ADDENDUM # 1

PROJECT: Fore River Short Stay Hospital, Portland, Maine

PROJECT NO: 05-4898

DATE: November 22, 2006

Drawing Title and Number  
 East Building Elevations  
 & Coursing Details

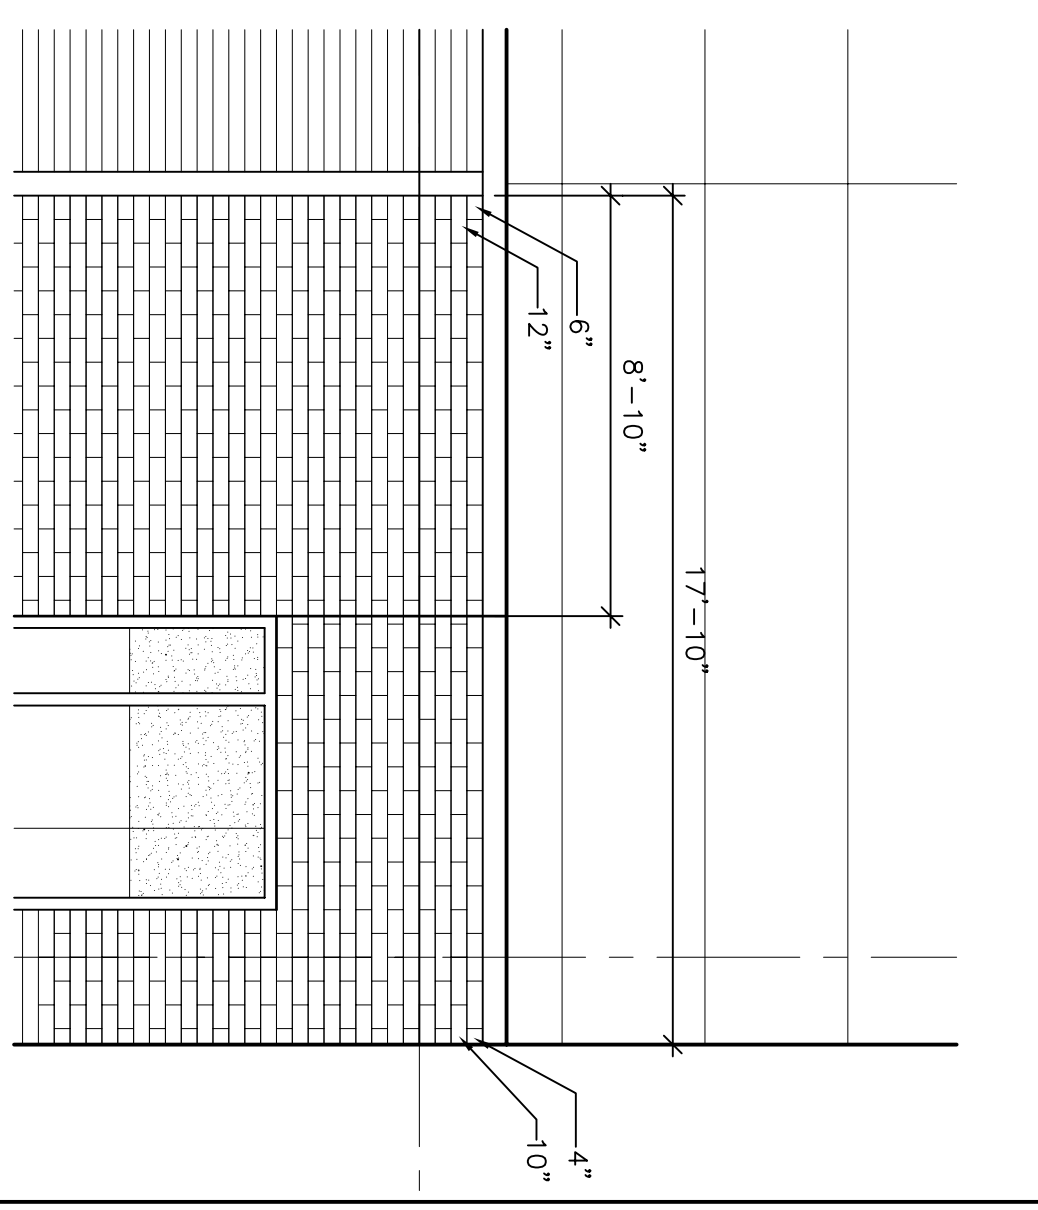
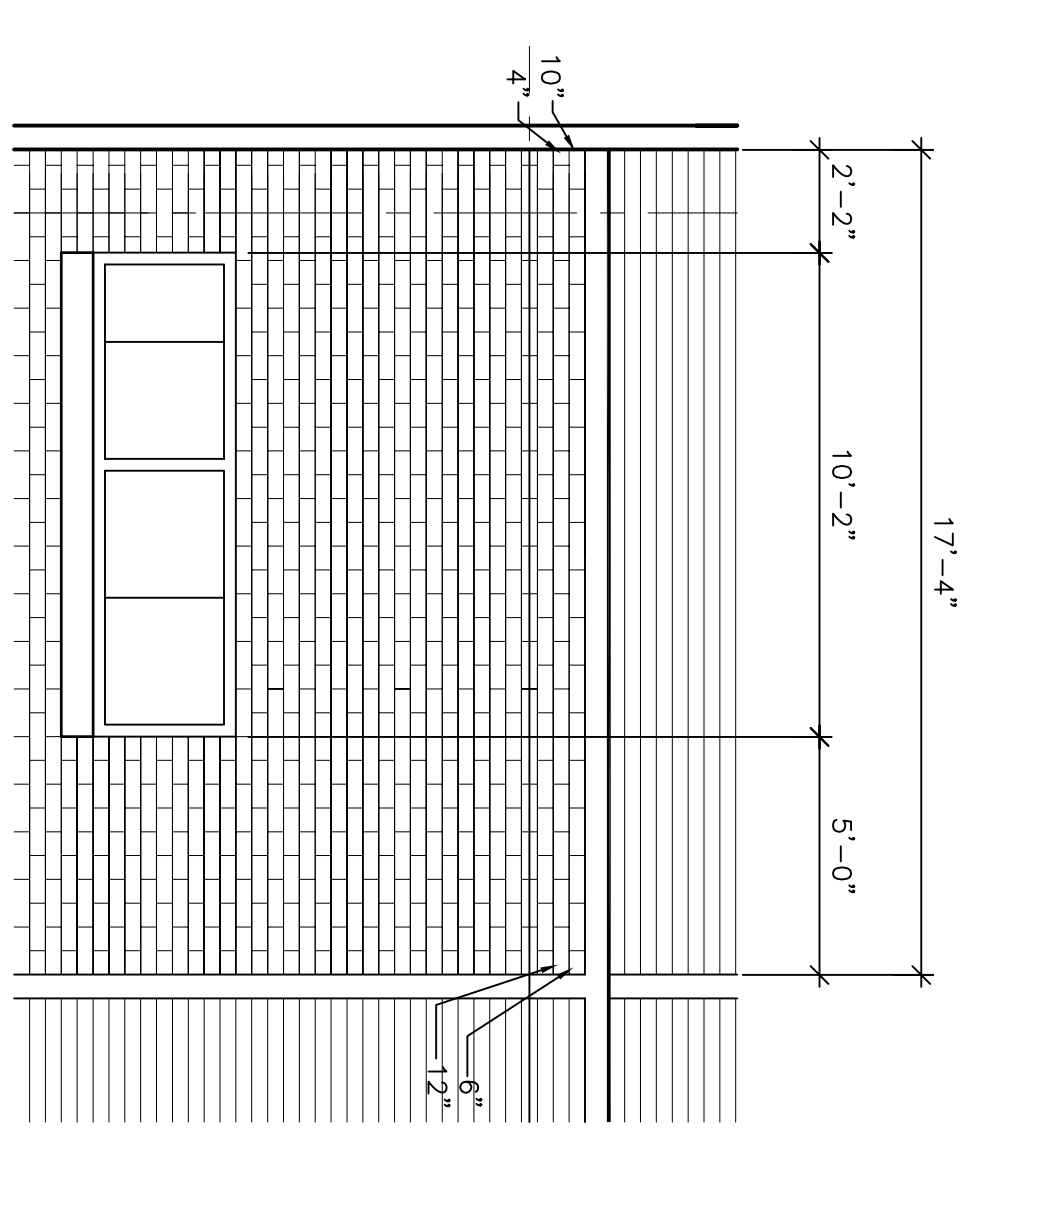
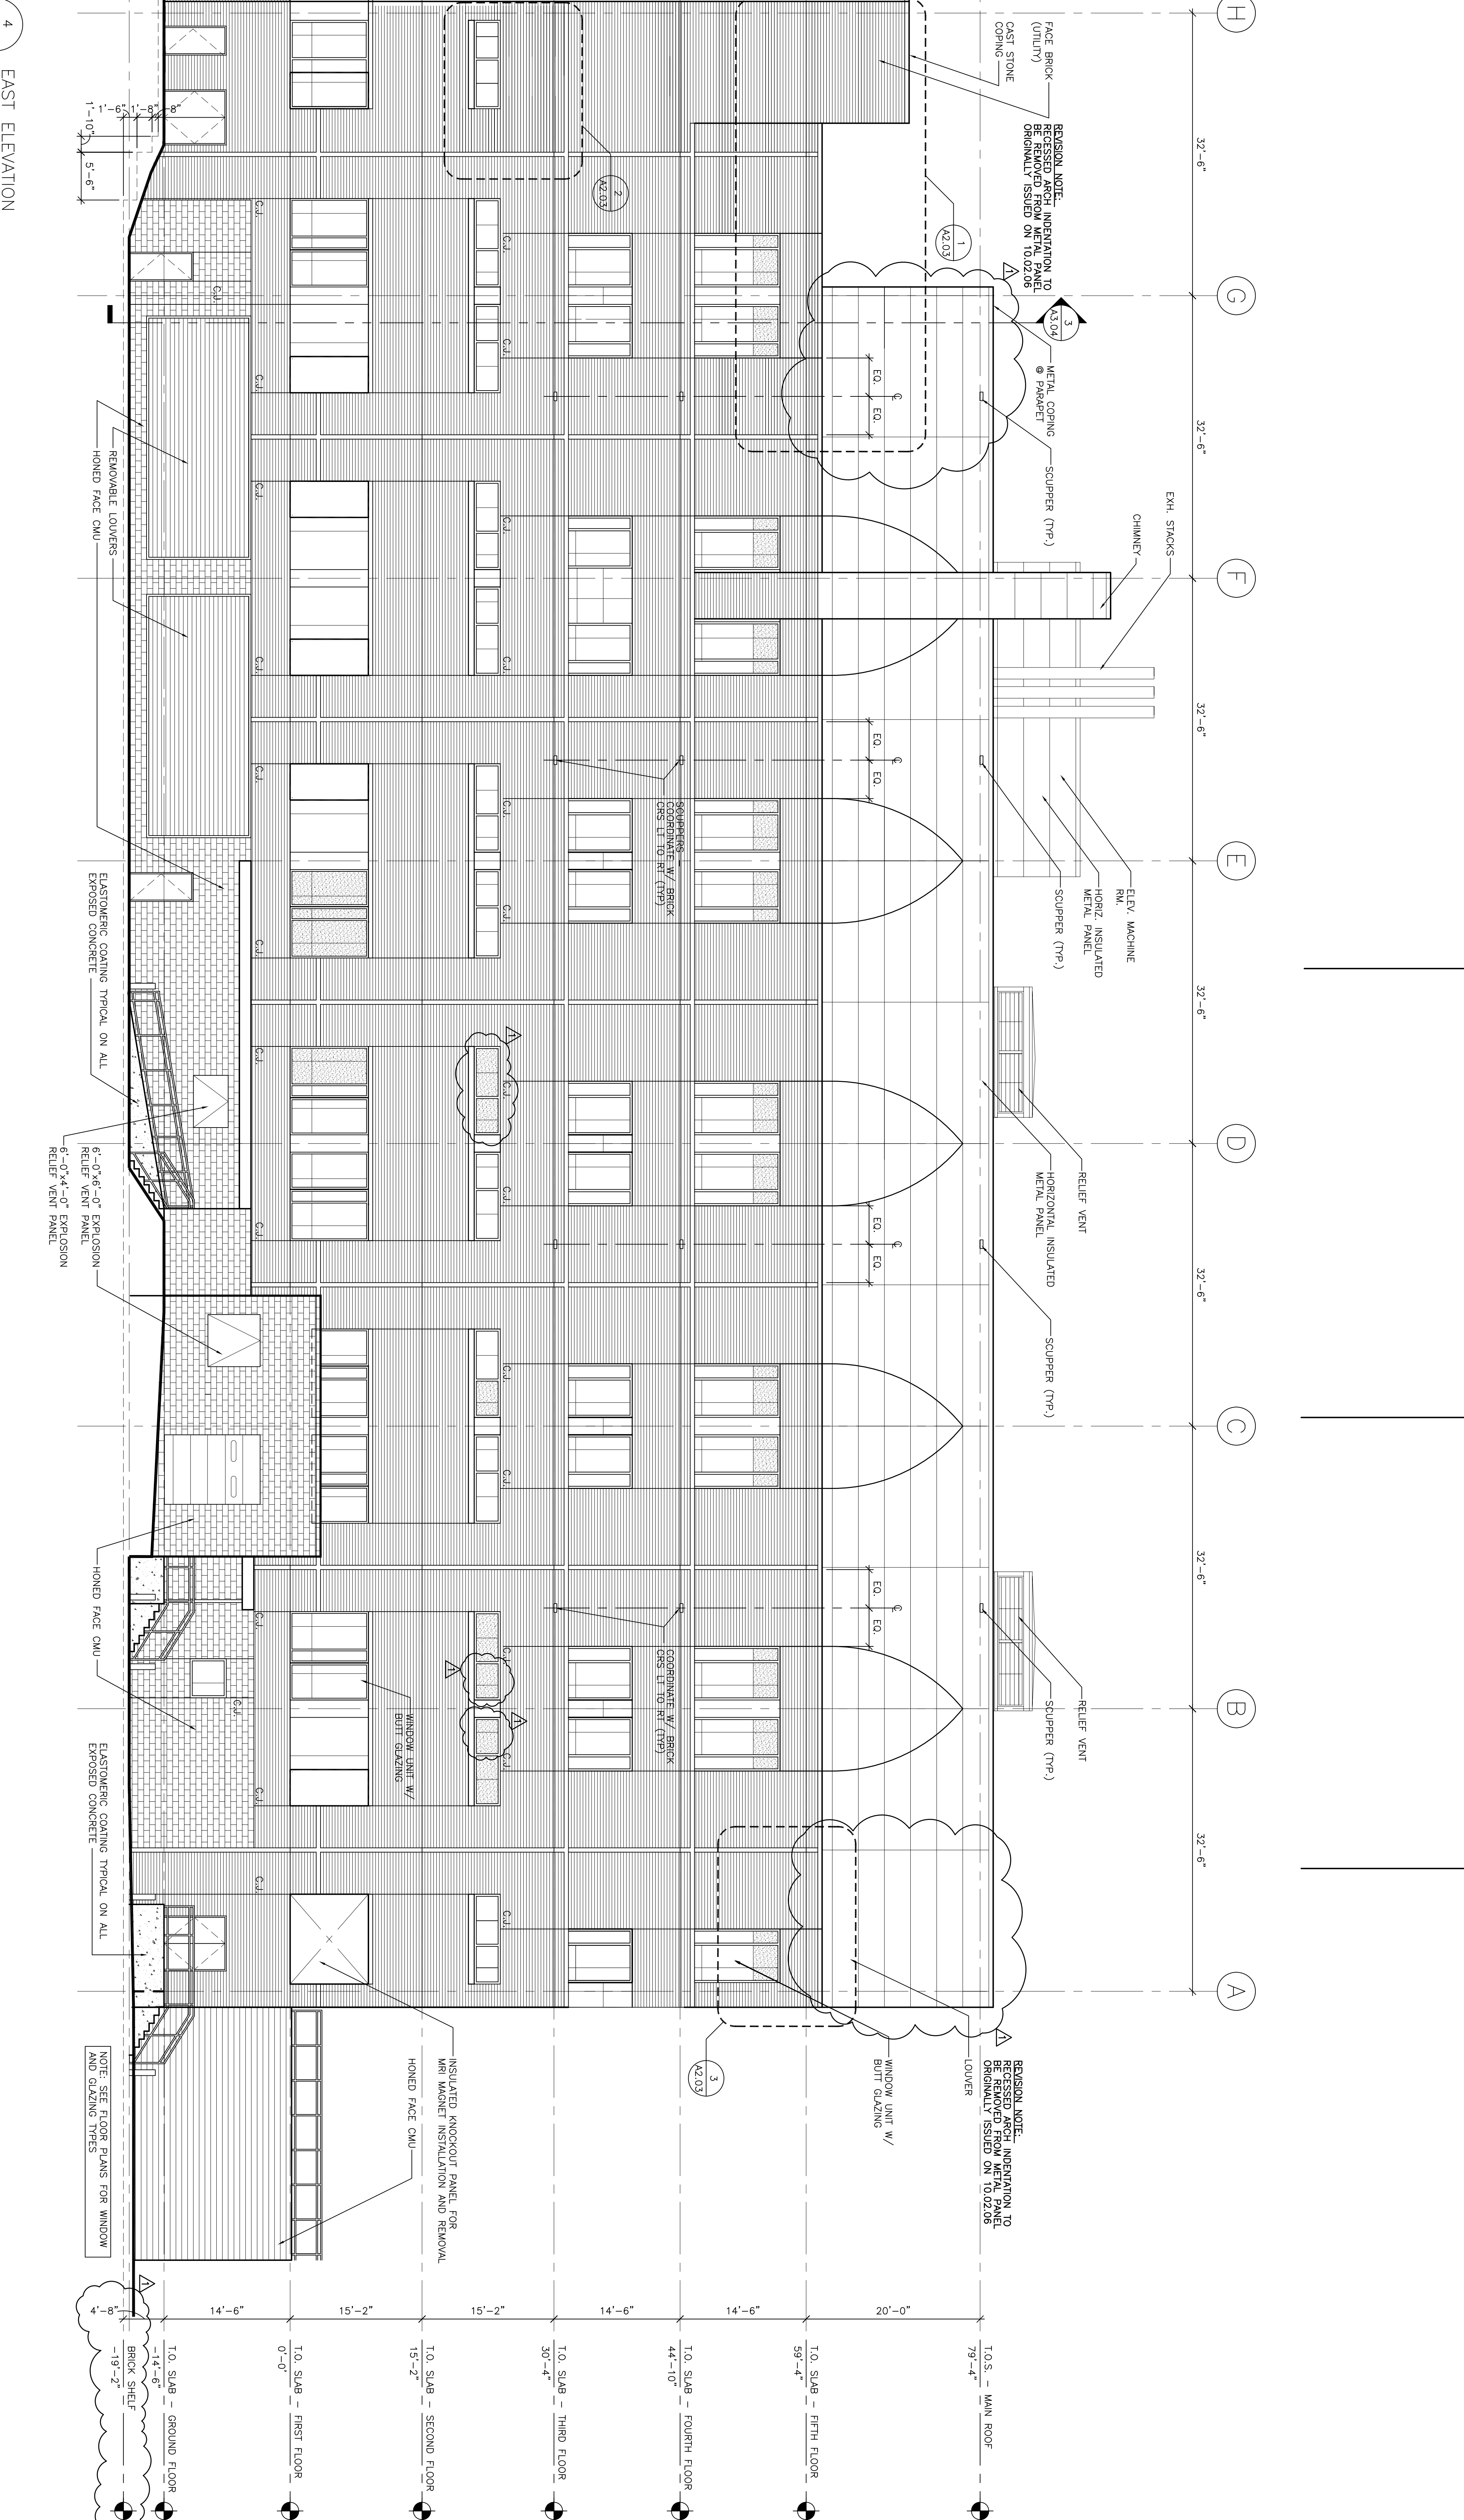
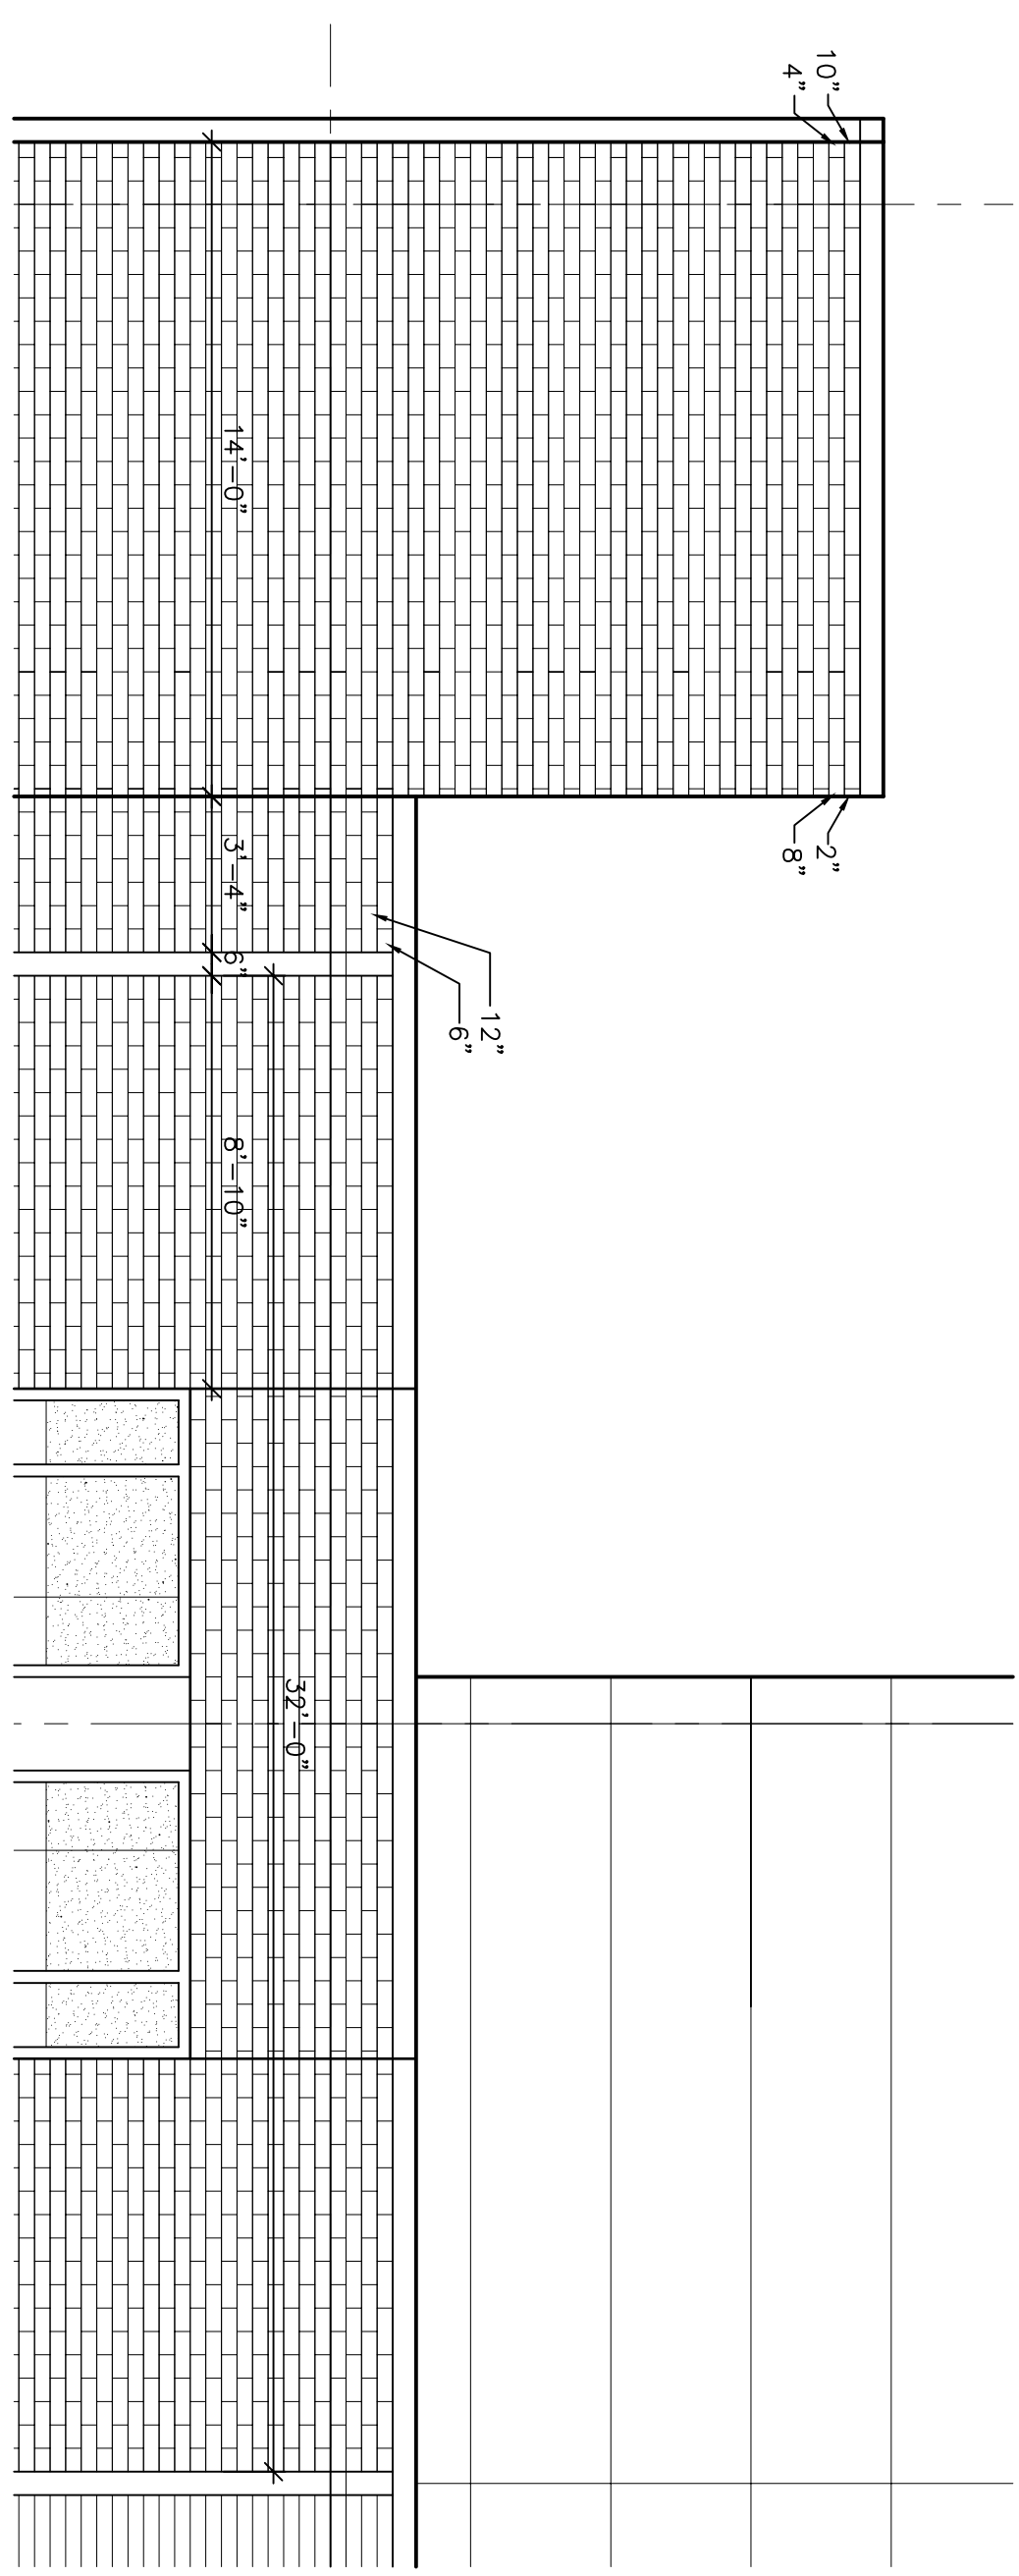
- A. Drawing FP1.00
 - 1. Added sprinkler riser and notes for fire protection in chute
 - B. Drawing FP1.01
 - 1. Added notes for fire protection in chute
 - C. Drawing FP1.02
 - 1. Added sprinkler riser and notes for fire protection in chute
 - D. Drawing FP1.03
 - 1. Added sprinkler riser and notes for fire protection in chute
 - E. Drawing FP1.04
 - 1. Added sprinkler riser and notes for fire protection in chute
- C. ADD the following Sketches
- 1). SKA-3 “Ground Floor Plan – Dimension Revision to A1.01”
 - 2) SKA-4 “East Elevation – Revision to A2.03”
